**Lancashire Gardens Trust**  
*Conservation & Planning Group*

**Proposed demolition of existing dwelling, erection of replacement two storey four bedroom self build dwelling with detached double garage and associated site works. Application 3/2025/0006.**

**Avenue Farm, Avenue Road, Hurst Green BB7 9QB. JCNAS Ref 202639.**

Drawing Title
PROPOSED SITE PLAN

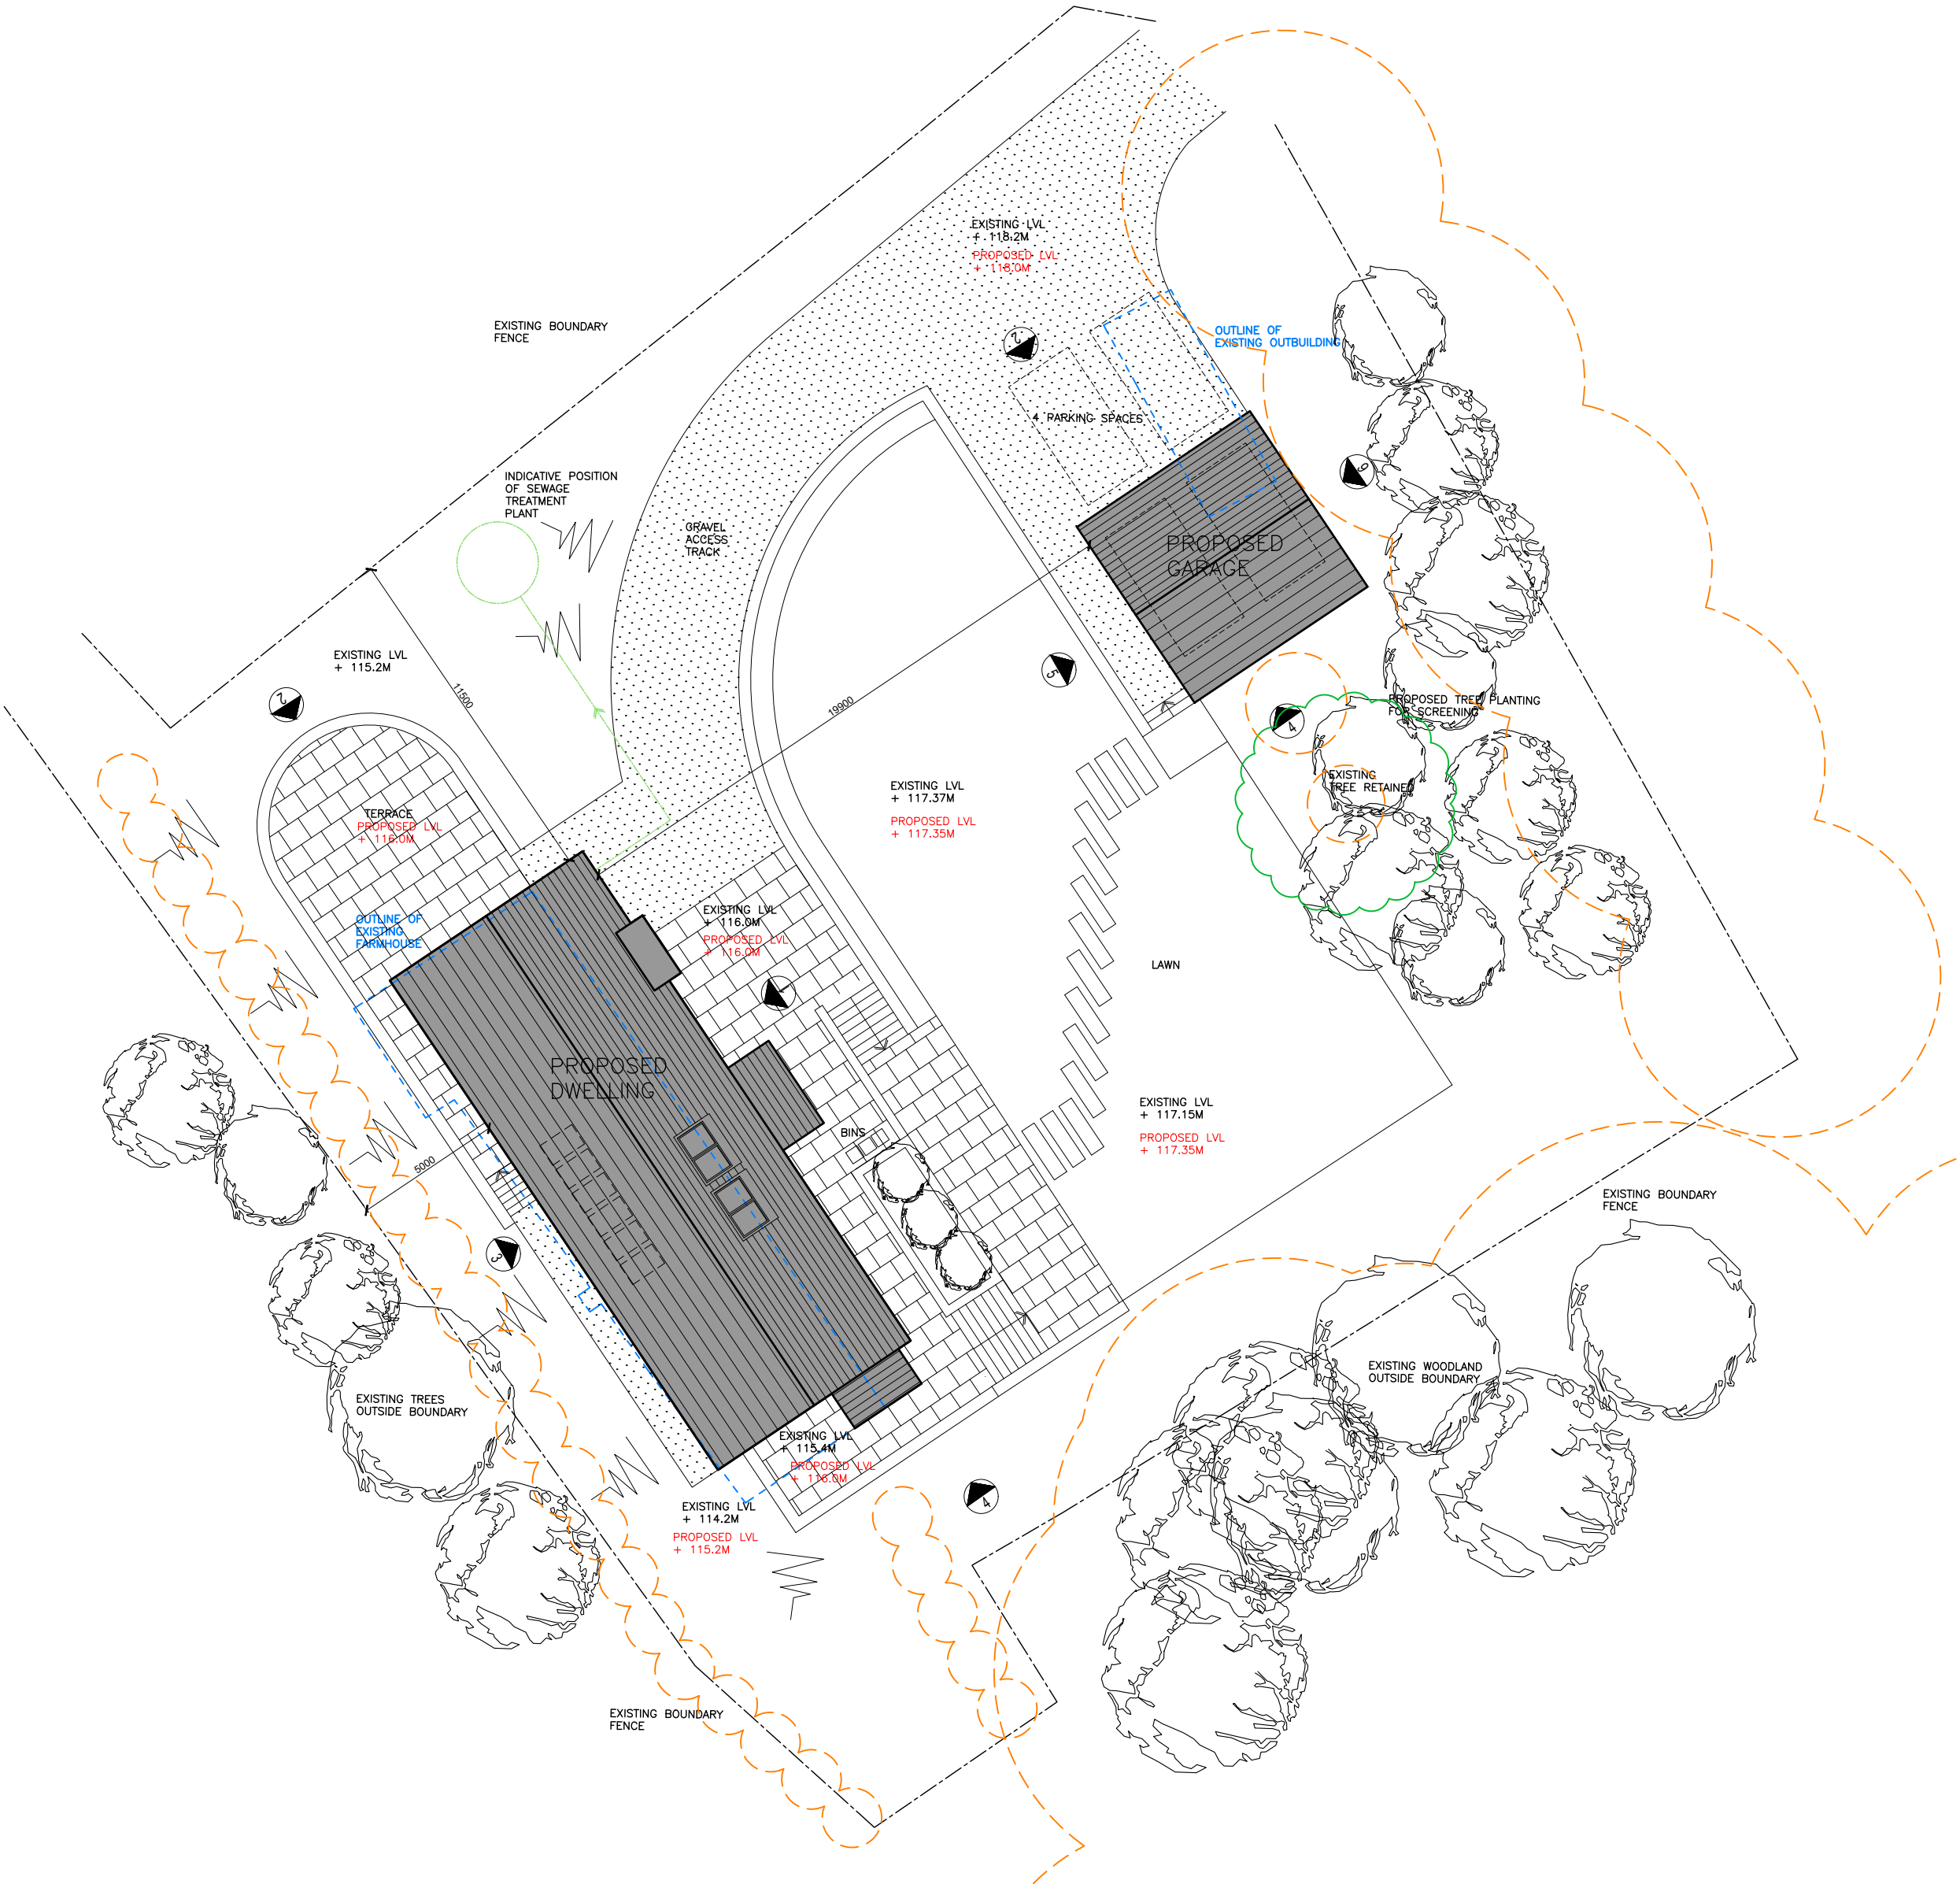
Our view remains that the site is almost fully screened from Avenue Road by existing woodland. However the access which is included within the redline is within the RPG. As far as we can determine there is no proposal to upgrade or alter this existing access in any way. In the earlier application the highway authority commented that the first five metres of driveway will require to be surfaced. This also applies to the current application. We note that Historic England response on the earlier application required that there be no alteration to the driveway but in the current application they have made no comment. If unavoidably the driveway is to be formalised we recommend that this is treated in the most low key manner as possible ie without the use of upstanding road kerbs for instance.
